DRAINAGE AND TRANSPORTATION INFORMATION SHEET

February 16, 2024

Re: Markana Flats
7050 Constitution Ave. NE
Traffic Circulation Layout
Architect's Stamp 08-16-23 (J19-D047A)

## ARCHITECTURAL SITE PLAN

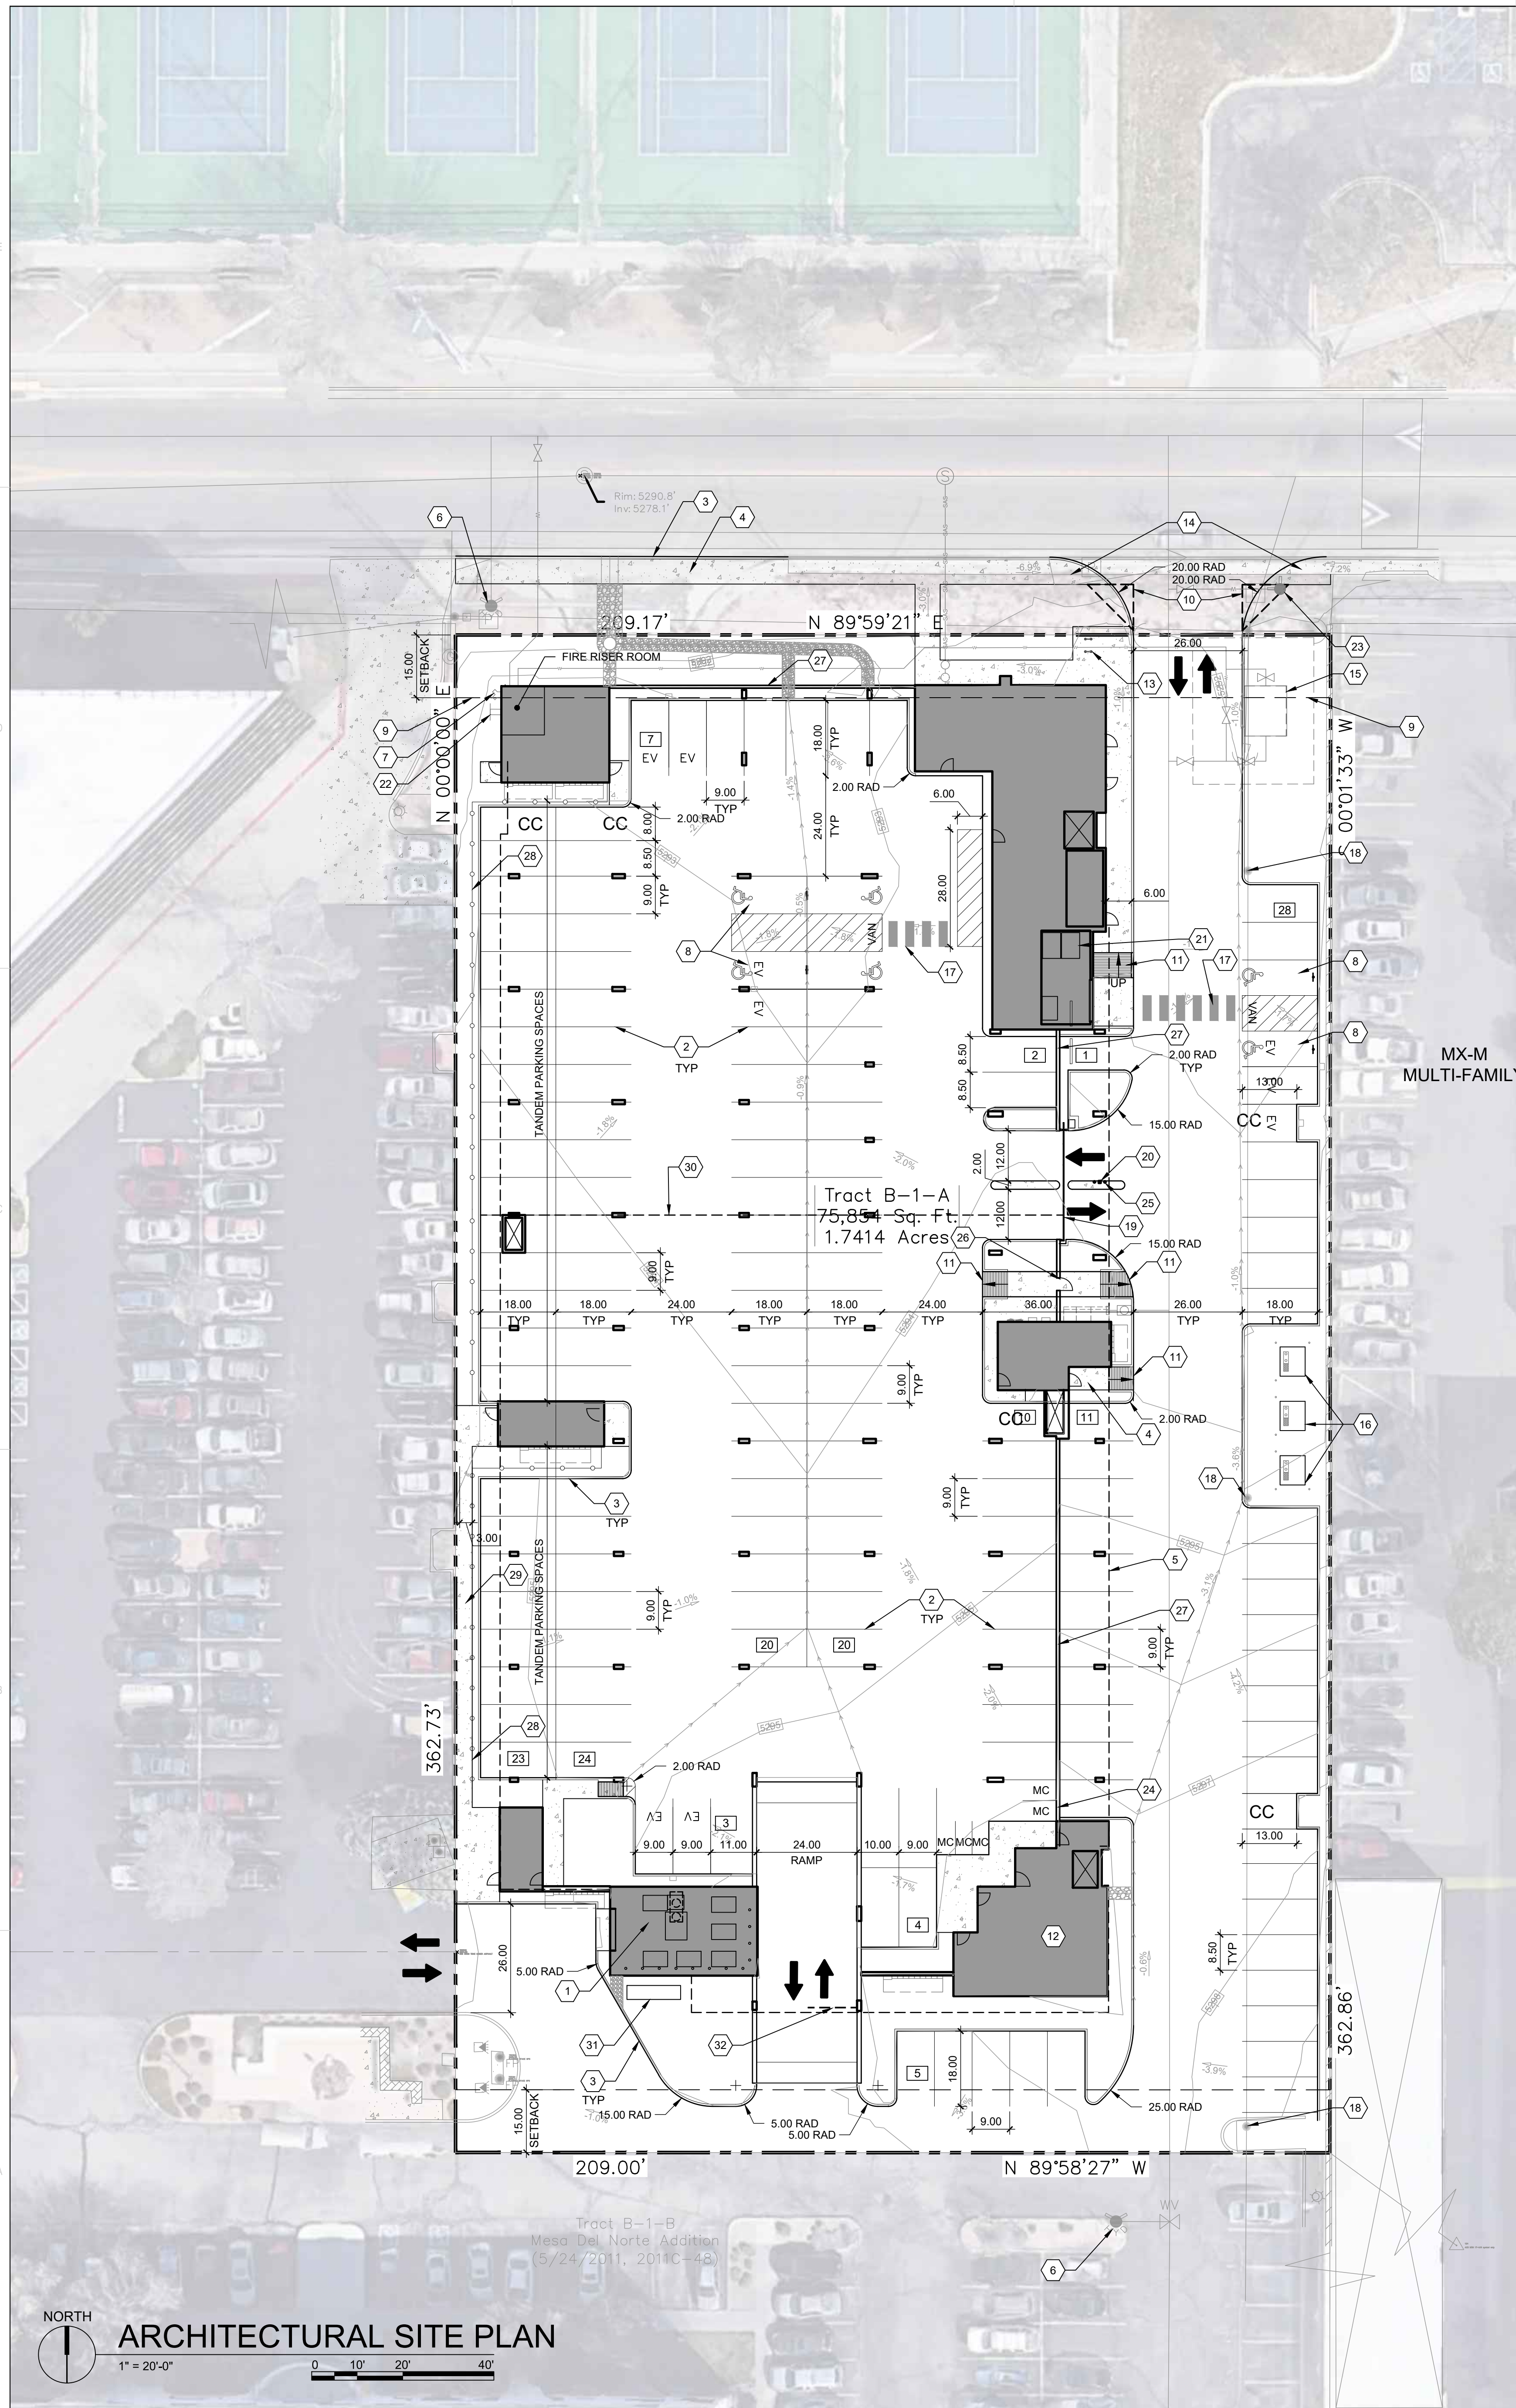
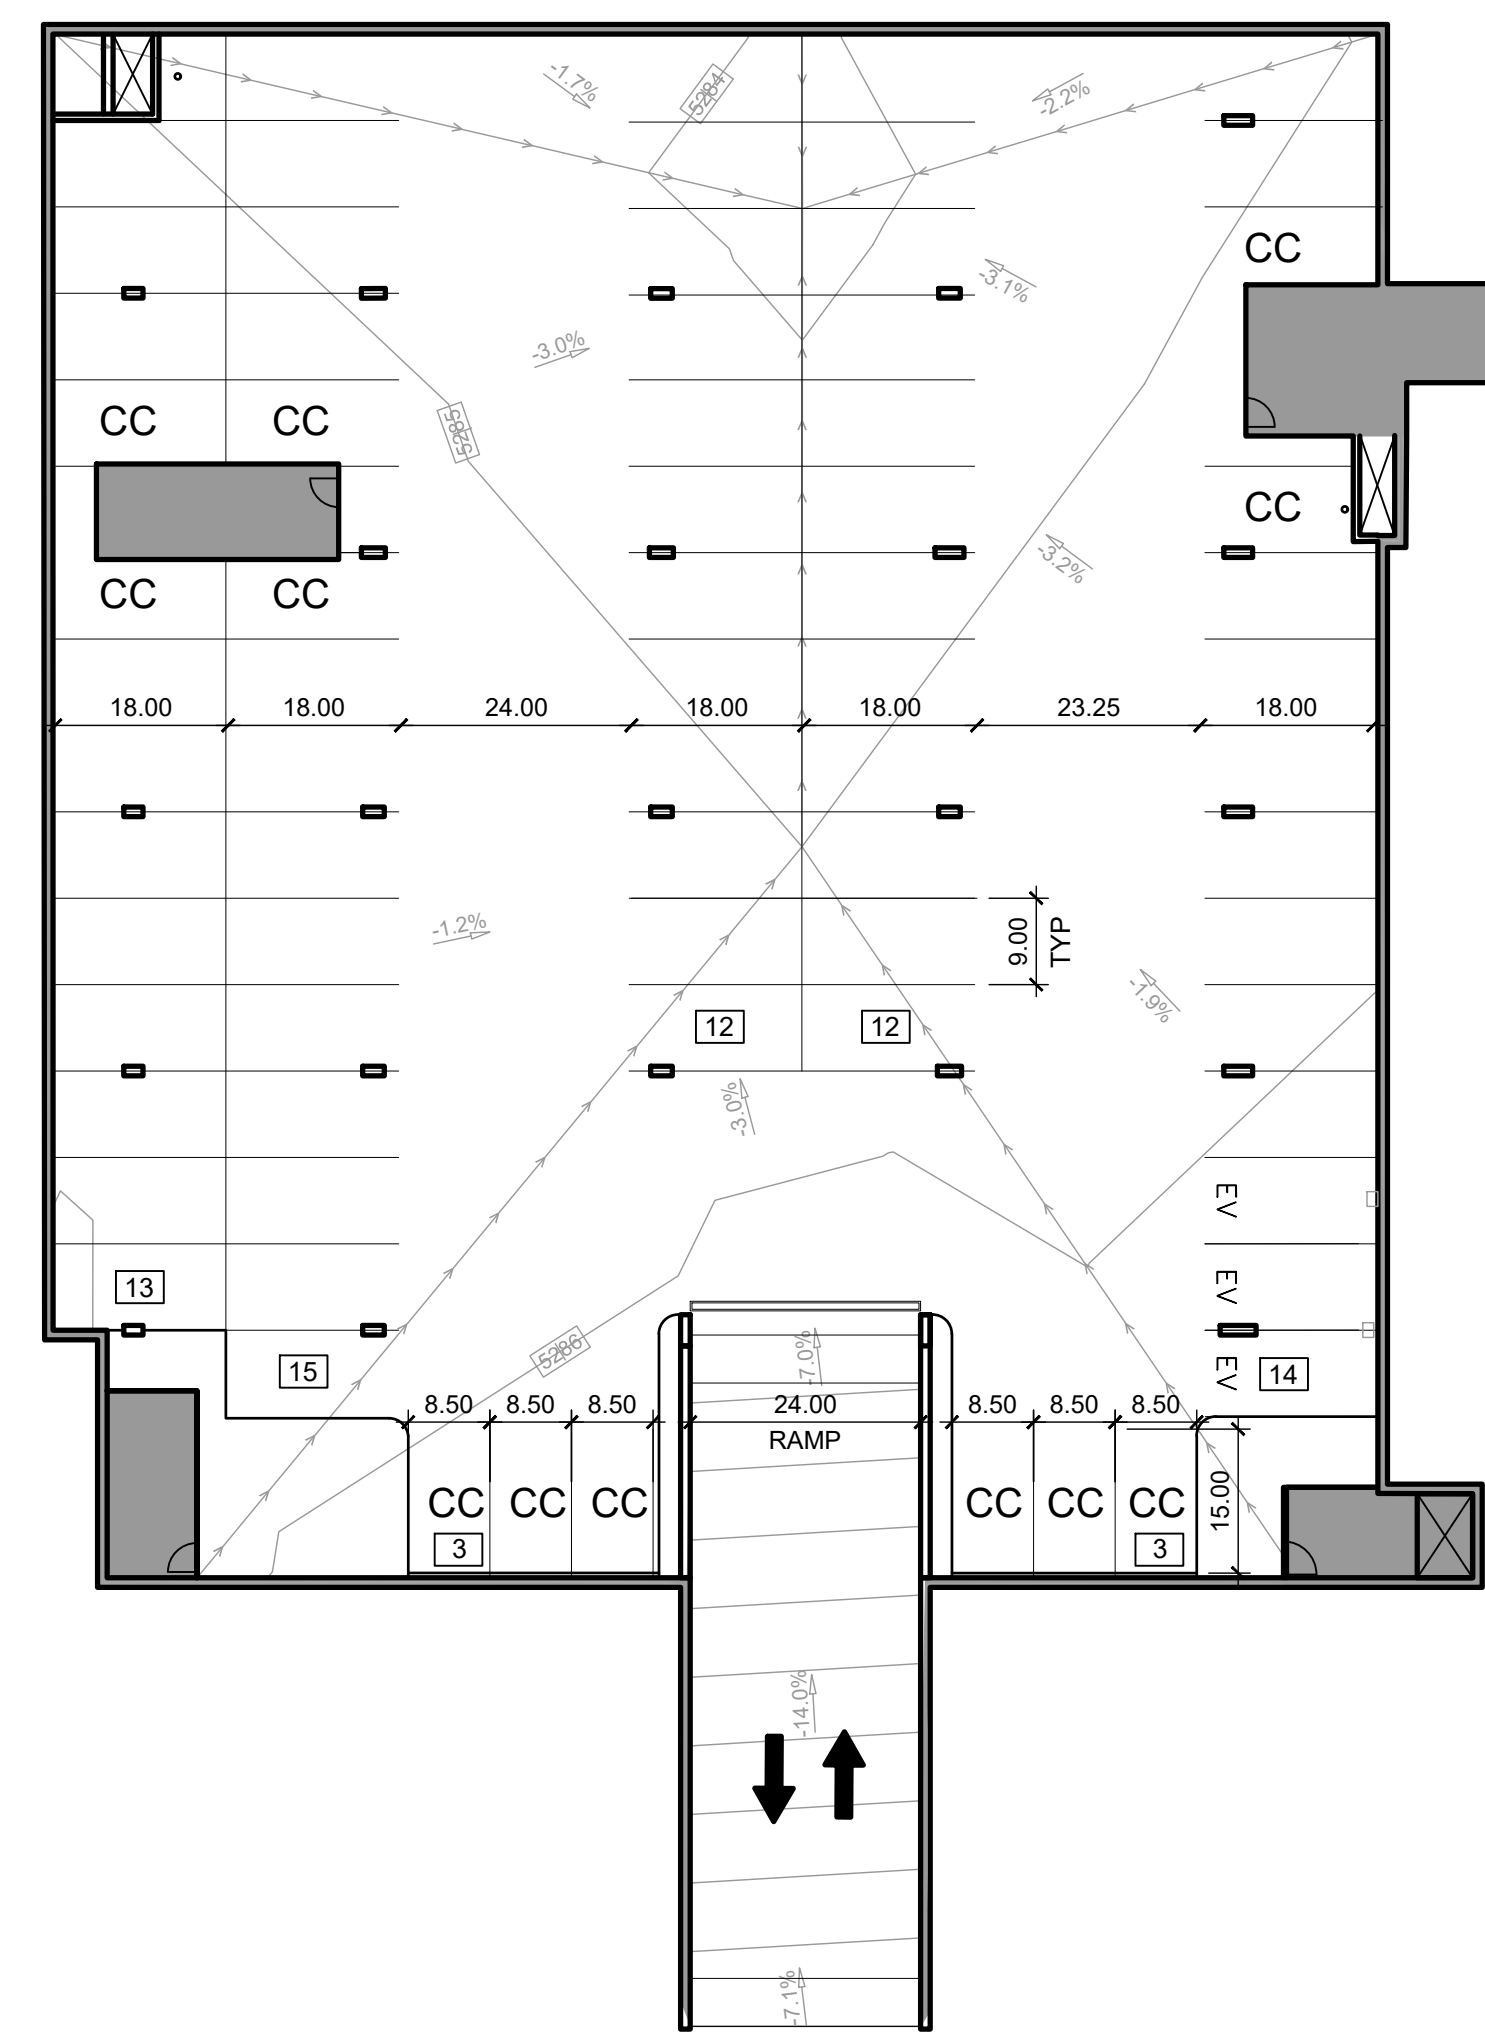
2. Per Google aerial view, there are power poles on the east side of the site. Please show those poles on the site plan and provide an easement. *See revised plan*

3. Please explain how the Tandem Parking spaces will be managed? *Tandem spaces will be leased to tenants as a pair*
4. Show on the parking table requirement, how many Motorcycle and EV parking space are required. *See revised site plan*

6. Keynote 10: please show on the site plan the dimensions of the clear sight triangle. *Dimensions added to the site plan*
7. A 5 ft. keyway is required for dead-end parking aisles for the lower level plan. *See revised plan*

8. Please show on the site plan how wide is the concrete columns to ensure that they do not impact the width of the proposed parking spaces. *See revised plan. The columns are 1' wide leaving 8'6" clear at spaces with columns*

10. Label the compact parking spaces by placing the words "**COMPACT**" on the pavement of each space. *The word "COMPACT" has been added to those spaces*

11. Keynote 27: Parking areas shall have barriers to prevent vehicles from colliding with the wall/ fence. *All walls in vehicle parking/circulation areas have a 3'-6" high reinforced concrete base in compliance with IBC 406.4.2. This note has been added as general note M on the site plan*

13. Provide a copy of Fire Marshal approval. *See attached approved fire 1 plan*
14. It is not apparent what type of pavement surface is being proposed. A hard driving surface will be required as part of this proposed project for parking area and drive aisles. *drive aisles and parking areas will be asphalt paving see general note "G" on the site plan*

15. Please specify the City Standard Drawing Number when applicable. *See revised site plan and keyed notes 33 and 34*
16. Add a note stating "All broken or cracked sidewalk must be replaced with sidewalk and curb & gutter." A build note must be provided referring to the appropriate City Standard drawing. *See general note "K" on the revised site plan*

E4  
FLUSH CONCRETE  
SIDEWALK

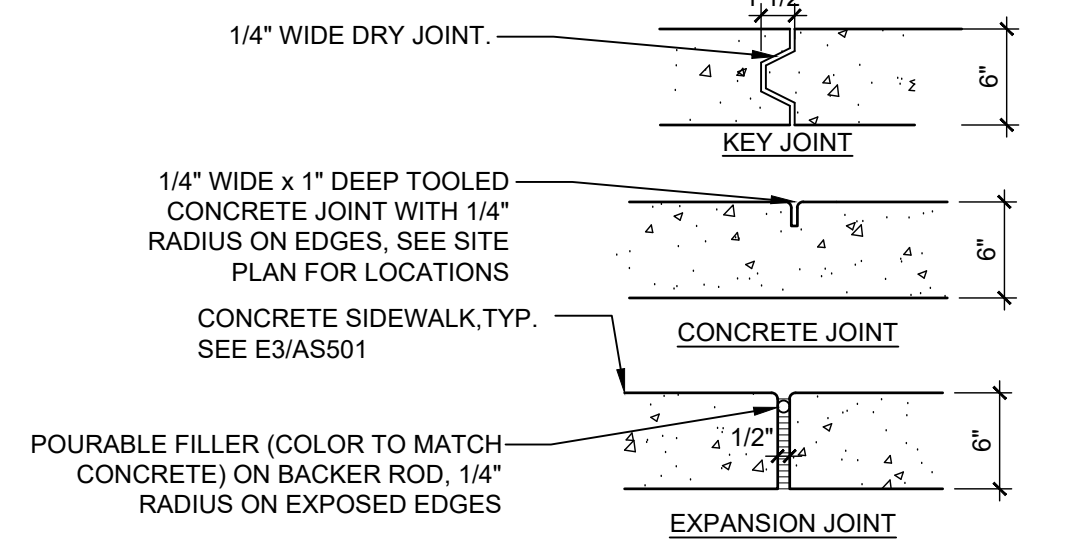
9. Please clarify whether the ADA pathways from the ADA aisles to the building entrance are flush all the way long. *Yes, the concrete sidewalks are flush with the asphalt at these locations. see revised plan and detail E4AS501*

B5  
POLE MOUNTED SIGN

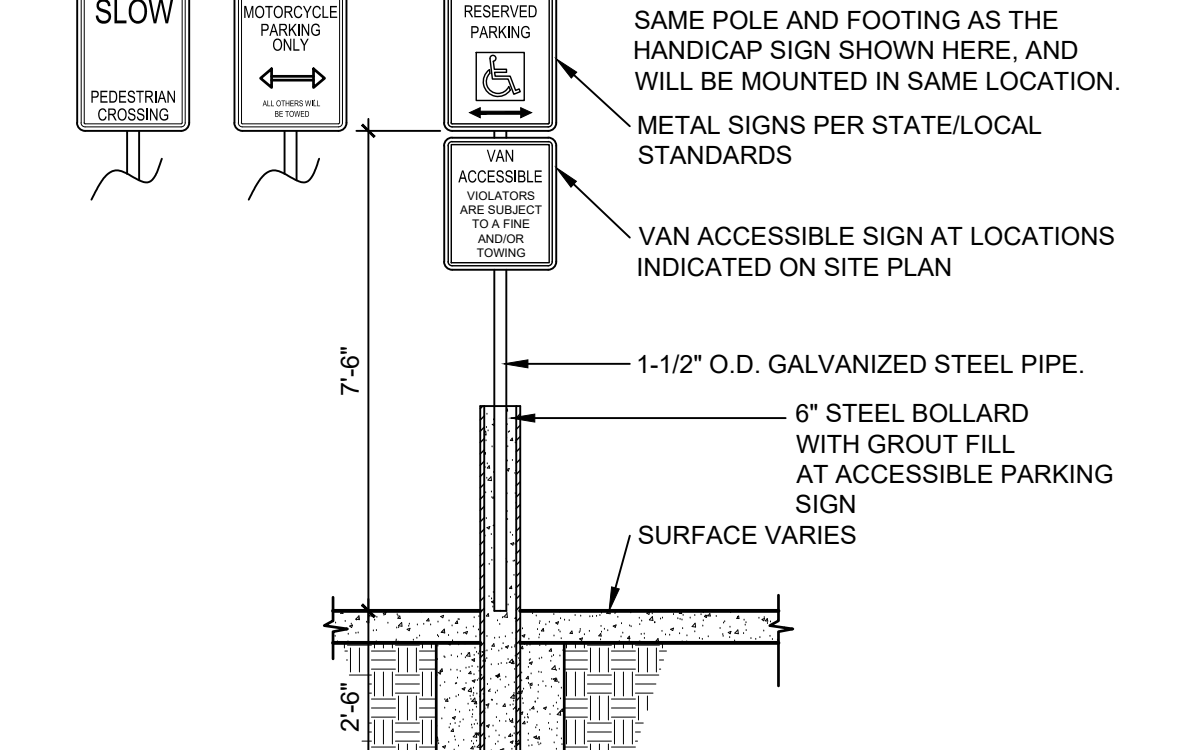
5. The ADA accessible parking sign must have the required language per 66-7-352.4C NMSA 1978 **"Violators Are Subject to a Fine and/or Towing."** Please call out detail and location of signs. *See keyed note 35 on site plan and detail B5/AS501*
